F.A.O Mrs S Leeson, Planning Officer RE: F40/12

Change of use from Offices to Residential at church House, 94 Felpham Road felpham

I object to the above Planning Application on the following grounds:

PROPOSED GROUND FLOOR PLAN
Scale 1:100

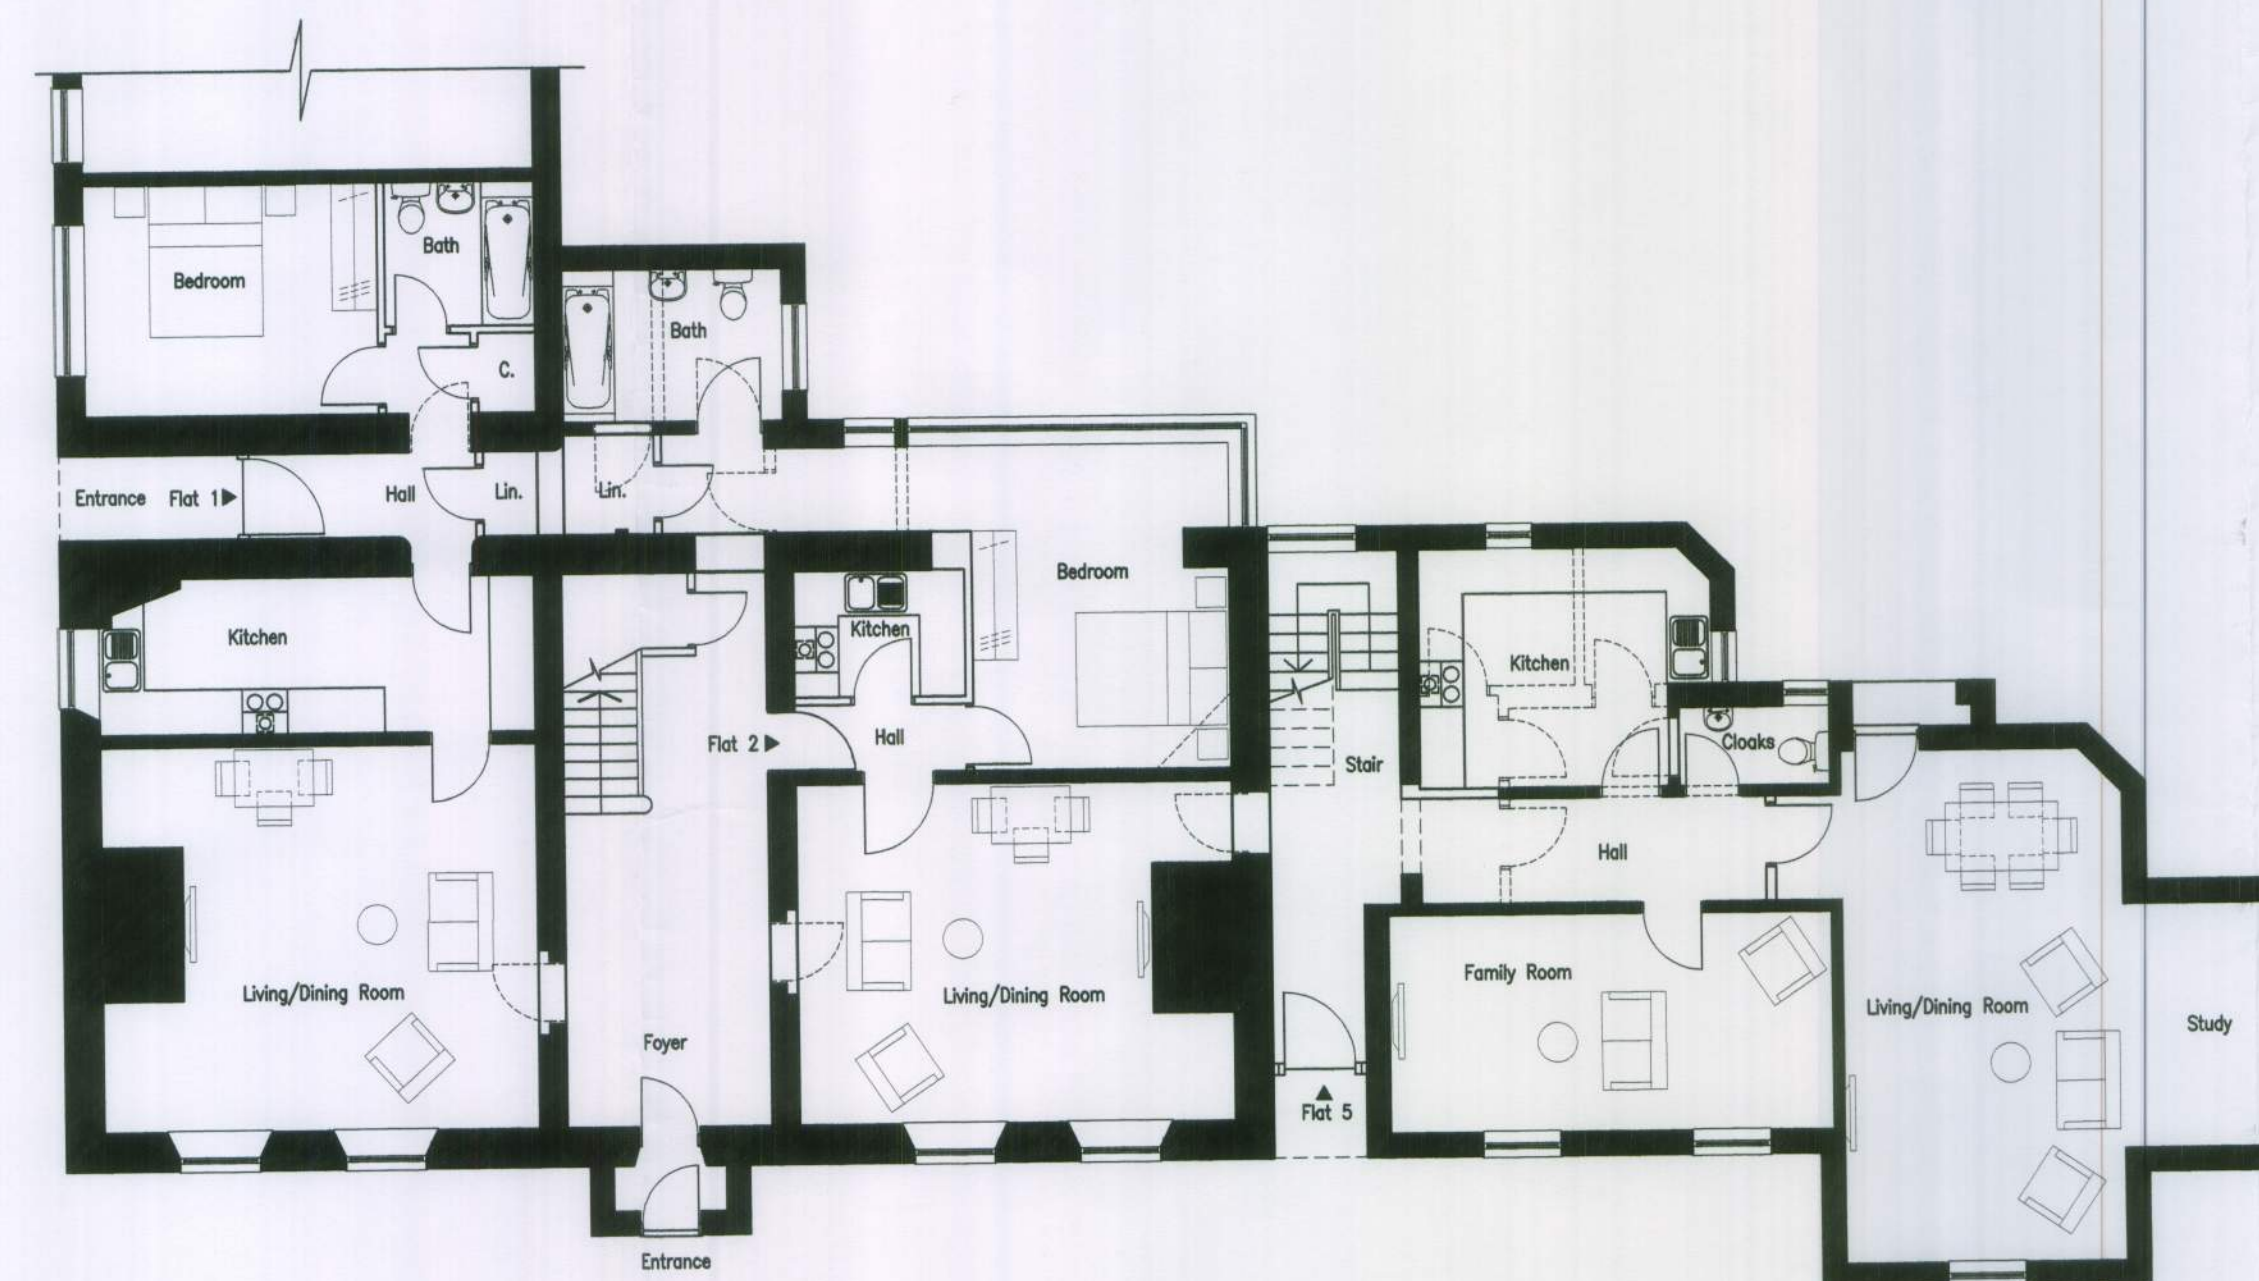
The plans at the moment are very sketchy but the proposed change to Church House would mean very over populated accommodation, where are the fire escapes, bin and recycling stores, outside space for washing etc, the parking is an issue, where would the visitors parking be, making a safe access in and out of Church House into either Limmer Lane or Felpham Road which is already a very busy and dangerous area. There would be 6 A.D.C bins and 6 Recycling bins for collection. Verdant will only collect from the boundary of Church House which places them on the pedestrian walkway

The development as proposed will devalue my property due to the extensive over development of this lovely listed building and site. For the past 46 years this building has been used as professional offices and should be kept as such, if there were to be a change of use to Residential there is the potential for bedsits and further inappropriate development to go ahead. The proposed dormer windows at the front of the building would alter the proportional balance of the Building.
